Preferred Project Report Broadway Building

University of Technology Sydney
Project Application No. 09_0212

Submitted to the Department of Planning & Infrastructure
On Behalf of the University of Technology Sydney

October 2011 ■ 10092

Typical covered walkway section

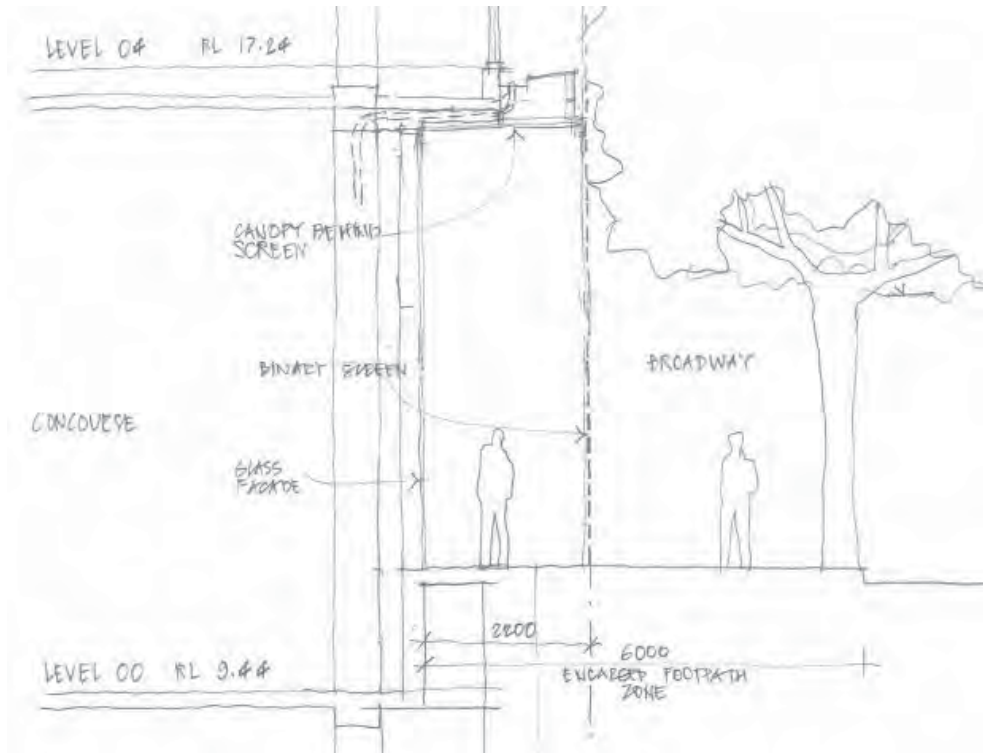
The City of Sydney, in its submission, raised concerns about the adequacy of weather protection in the undercroft between the screen and the building along Broadway and impacts on pedestrian amenity. The matter was further discussed in a meeting between the University and City officials (Graham Jahn and others, 16 June 2011) where a width of 2.5 to 3 metres for the undercroft was suggested.

In response to the issues raised by the City of Sydney, the proponent has increased the width of the undercroft by moving the southern glass facade of the building inwards at street level. This also required moving the columns behind. The new arrangement creates a covered walkway within the property boundary of a minimum width of 2.4 metres (see **Figures 1 & 2** and **Attachment 3**). Due to the skewed facade plate, the walkway widens to about 2.6 metres towards Wattle Street.

Any further adjustment of the glass facade (to achieve a 3 metre wide walkway) would have significantly compromised the structural components of the building.

N°1 Proposed lighting scheme Covered Colonnade
Background courtesy Denton Corker Marshall
N°2 Proposed Section Covered Colonnade

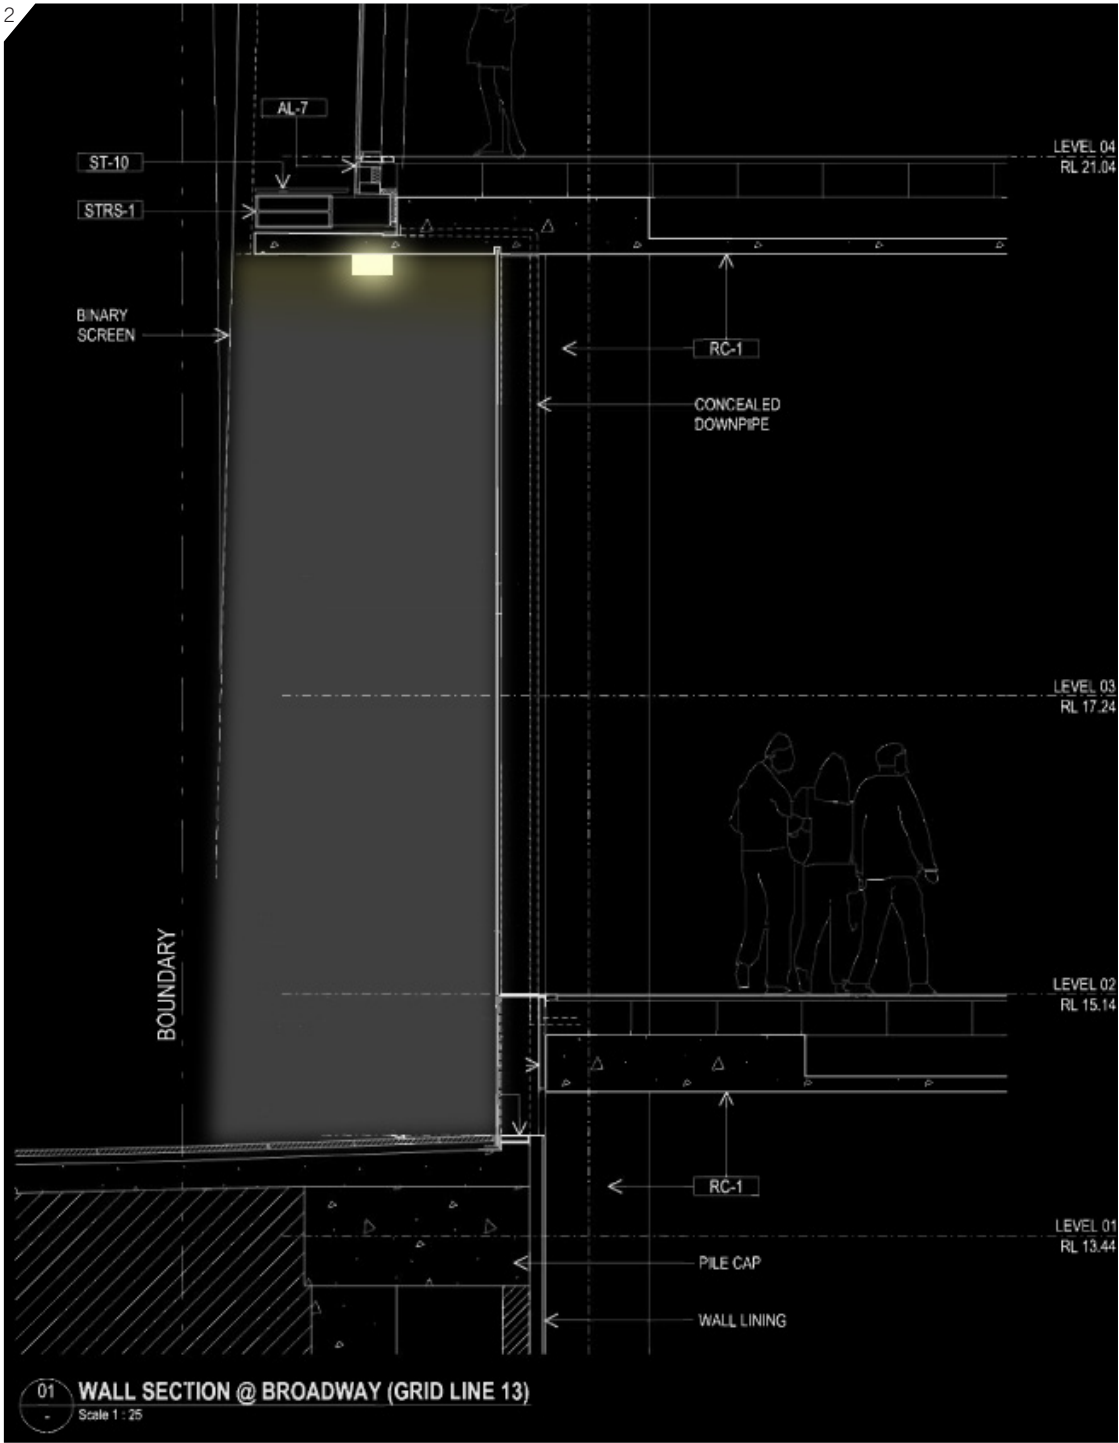
<p>Safety of space between the screen and the building</p> <p>The binary screen may provide a concealment hazard, especially when the building side is not illuminated. Measures should be implemented to provide passive surveillance at night, such as the provision of lighting within corridors.</p>	<p>Lighting and other measures have been incorporated into the design to facilitate surveillance of the space behind the screen, see Sections 3.2 and 3.4.</p>
<p>Weather protection</p> <p>CoS recommended that the external screen be adjusted to provide some weather protection along Broadway in order to improve pedestrian amenity, and that any awning treatment comply with Council's requirements. Alternatively, an independent lightweight weather protection awning should be provided to the satisfaction of the City of Sydney Council.</p>	<p>The colonnade has been enlarged to provide better protection, see Section 3.1.</p>

Once the building closes for the night, the area will continue to be illuminated from the canopy overhead. The specialist lighting consultant for the project, Electrolight, has indicated in the Schematic Lighting Report (see **Attachment 5**) that lighting levels for the colonnade will exceed AS1158.3.1 Category P7 (see Section 3.4 of this PPR).
